## KITTTITAS COUNTY COMMUNITY DEVELOPMENT SERVICES

March 28, 2019

**Subject: Palomino Fields Div 2 (LPF-19-00003) Final Long Plat – Staff Review and Request for Additional Information**

Surveyed by LMH Scale 1" = 300'
Drawn by Tml/FCS Sheet 1 of 5
Checked by FCS Project No. 18146

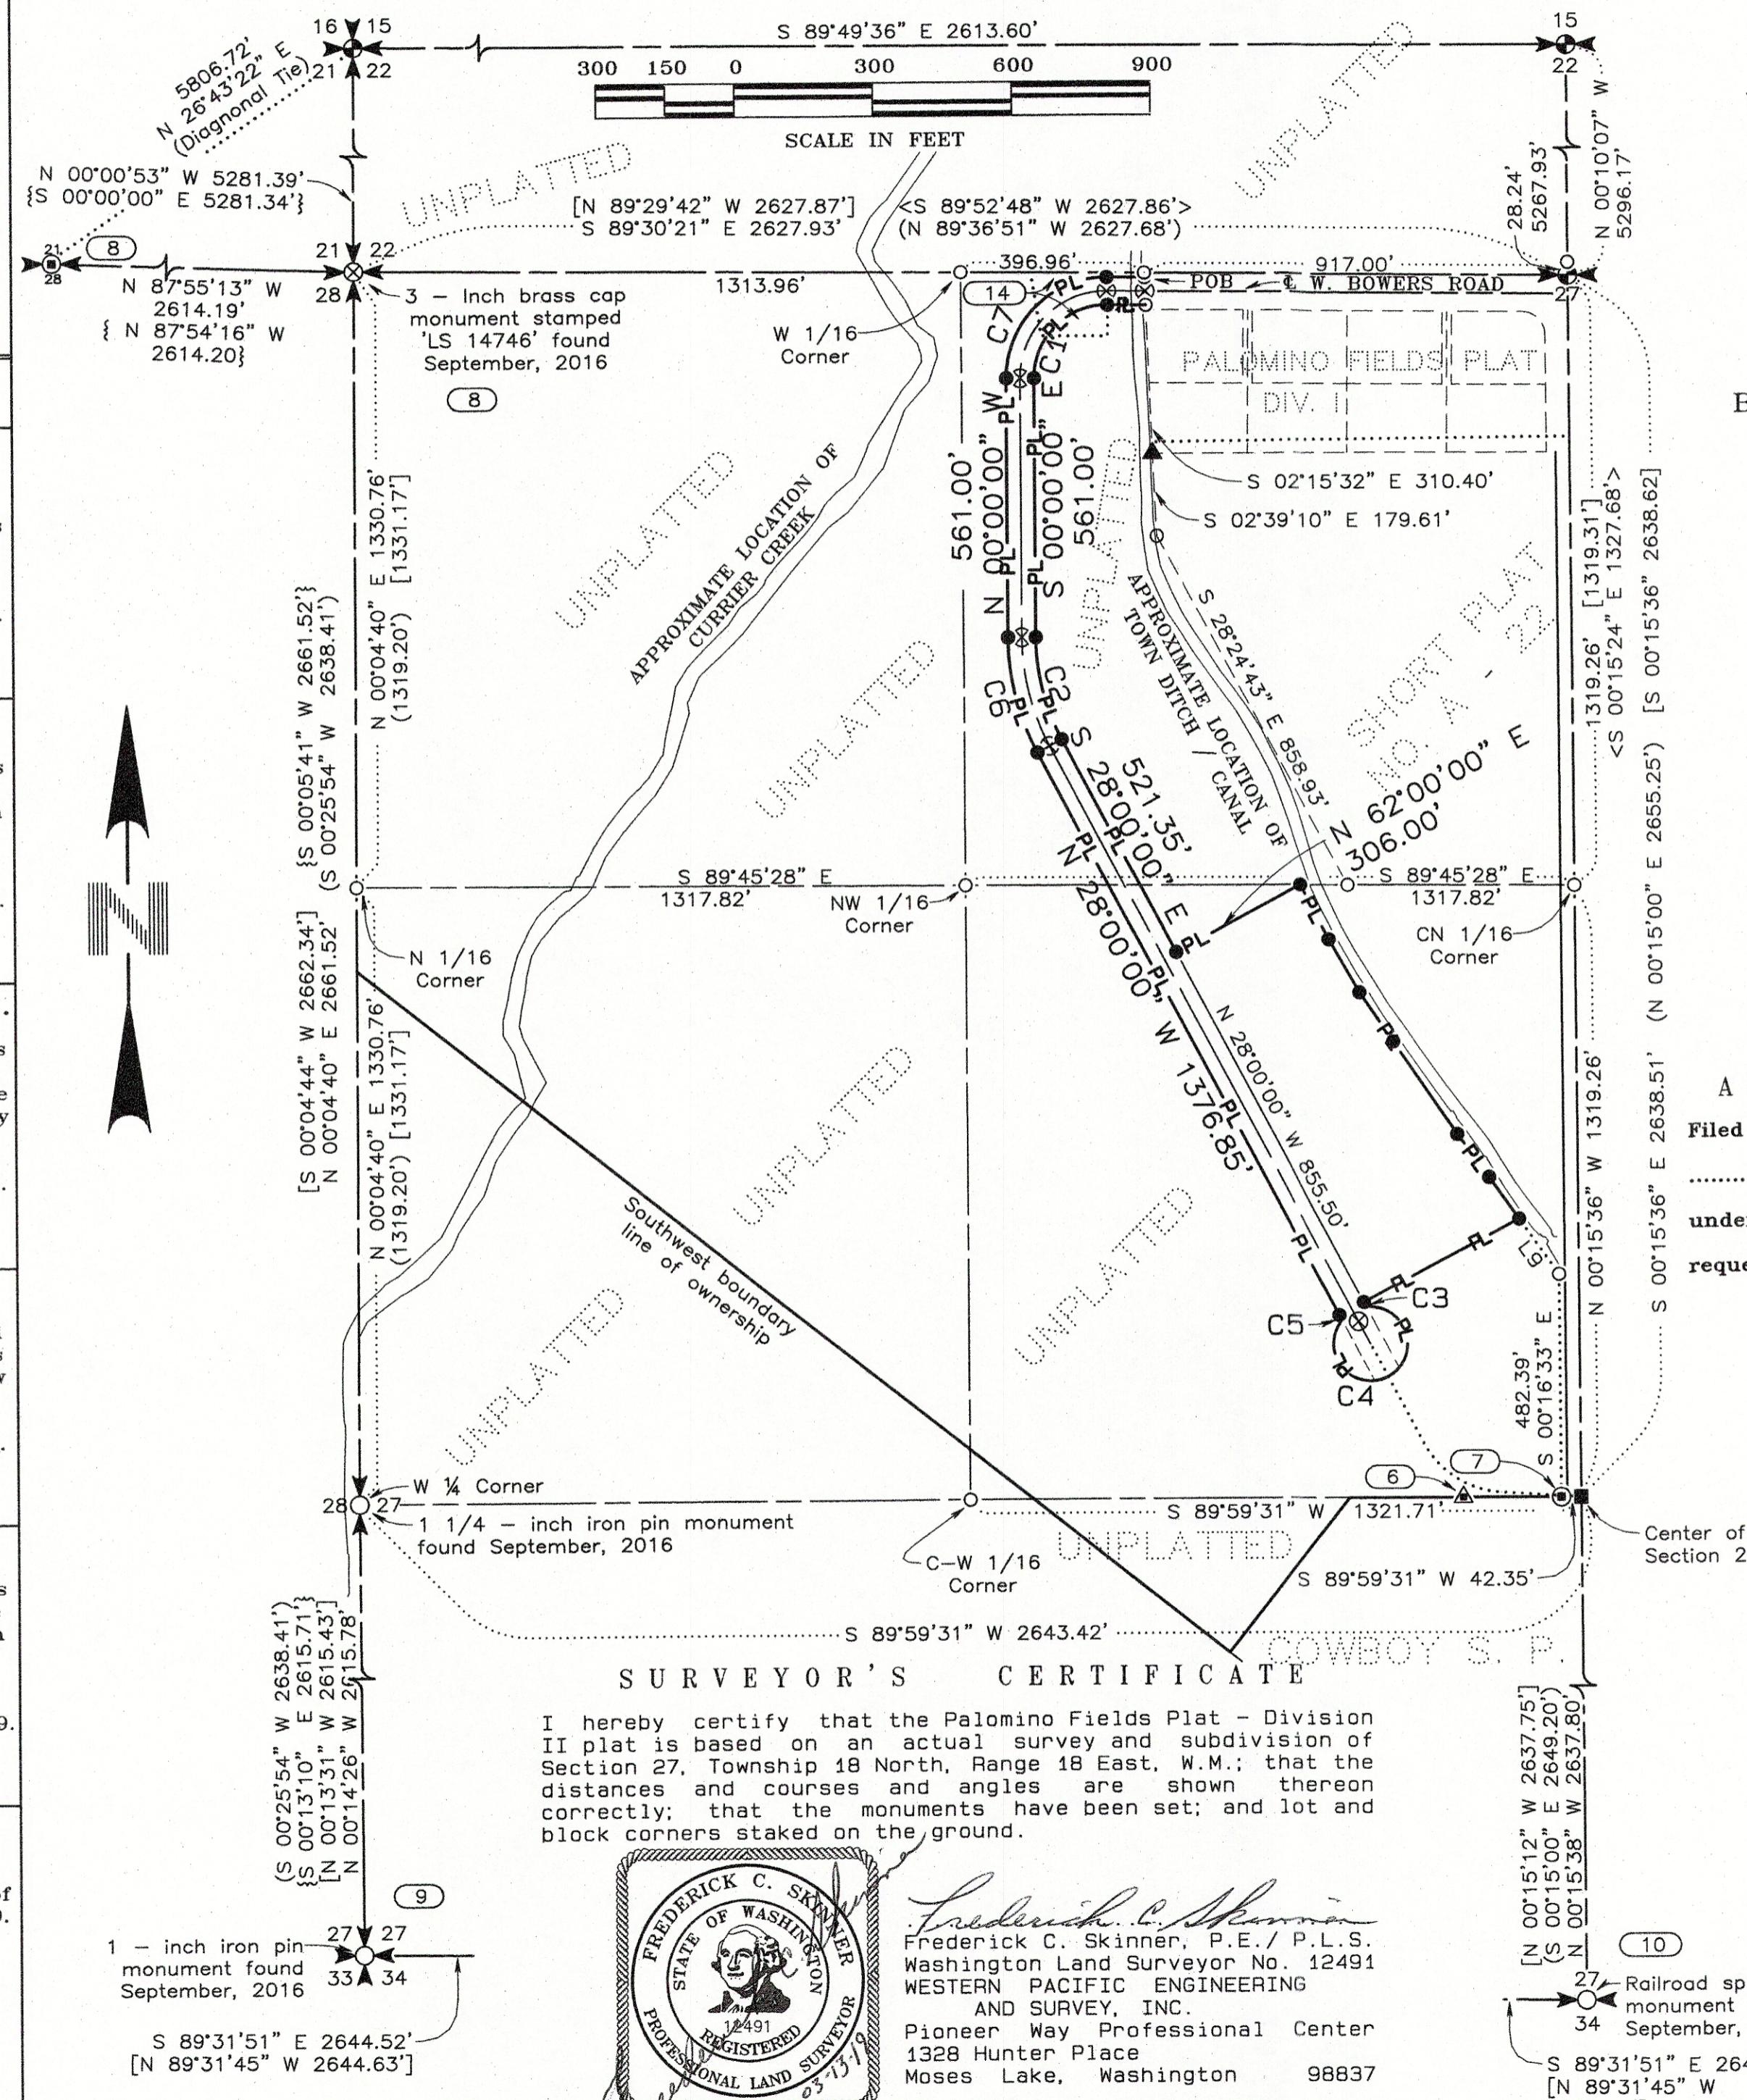
- An incorrect parcel number (471033) is listed in the Treasurer's and Assessor's signature box. This parcel was retired. The correct number is 491033.
- Parcels 11801 & 11802 should be listed in the Treasurer's box as well as the Assessor's box.
